April 13, 2015

**Subject: Century Tire Plaza – 195 Kennebec Street
Project ID# 2015-027
Review Comments Received April 8, 2015**

SHEET TITLE: SITE LAYOUT AND UTILITY PLAN

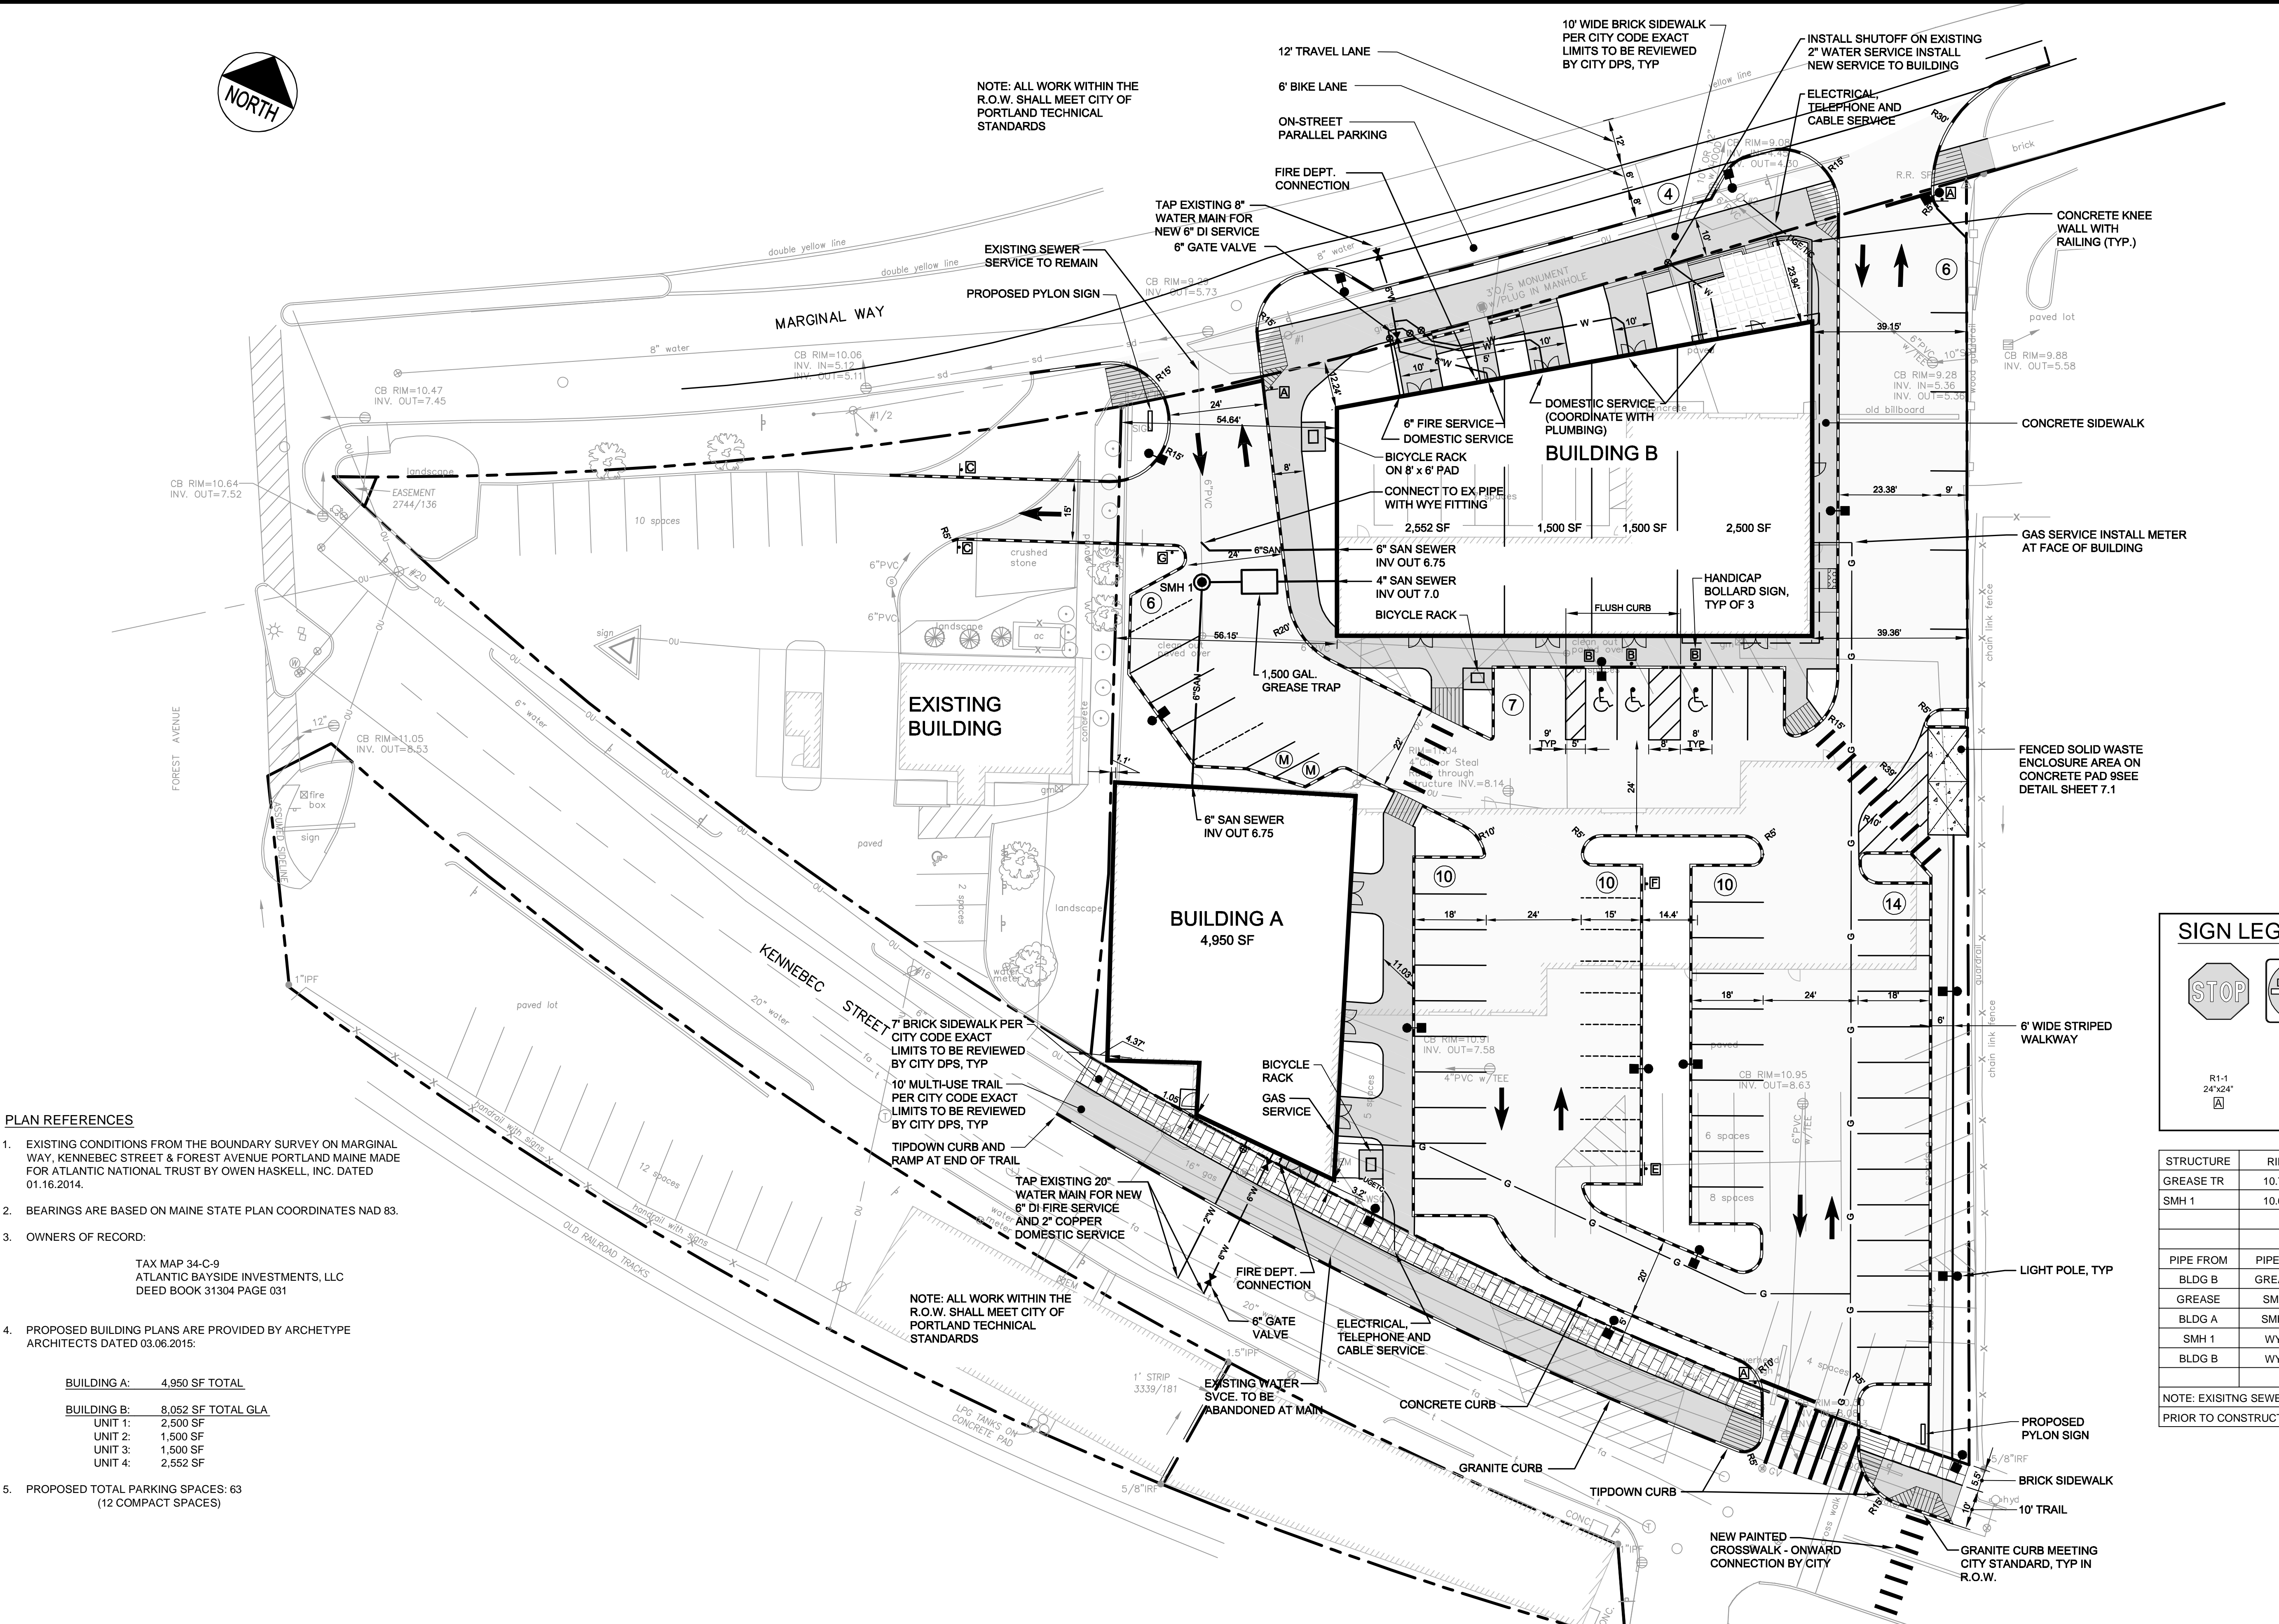
As requested, the plans have been revised to show a connection from existing Catch Basin A to new Catch Basin 3, which will discharge to Marginal Way. Additional notes are required regarding the abandonment of the pipe between Existing Catch Basin A and the existing catch basin in Kennebec Street.

The pipe and catch basin penetrations should be capped at Catch Basin A and at the connection in Kennebec Street; and preferably the pipe is removed or infilled with a flowable fill.

The plans should incorporate a full ADA compliant crosswalk on Kennebec Street between the site and Brattle Street (this crosswalk currently exists). Status: The plans should also include the construction of a ADA compliant ramp on the south side of the crosswalk on Kennebec Street. Plans shall be provided to the City for review and approval.

The configuration of the six parking spaces located along the Enterprise property boundary are non-standardized and dimensional standards are unclear and I would prefer a more traditional layout. Status: The applicant shall revise the configuration of these spaces to conform to standard parking space orientation. Plans shall be provided to the City for review and approval.

Please add notes to the plan denoting the street light specifications for both Marginal Way and Kennebec. This will help our inspectors during construction.

Notes have been added on the revised plans stating that the pipe penetrations into the referenced structures will be capped and sealed, as requested.

A ramp has been added on the south side of Kennebec Street.

The parking stalls in this area have been revised to further clarify the dimensions and ensure that they meet the city standards. We will continue to work with the City as necessary to ensure that the parking stalls will function as proposed within the site circulation.

A note has been added to the Site Layout and Utility Plan with the model numbers for the street lights and referencing the City Technical Manual Detail.
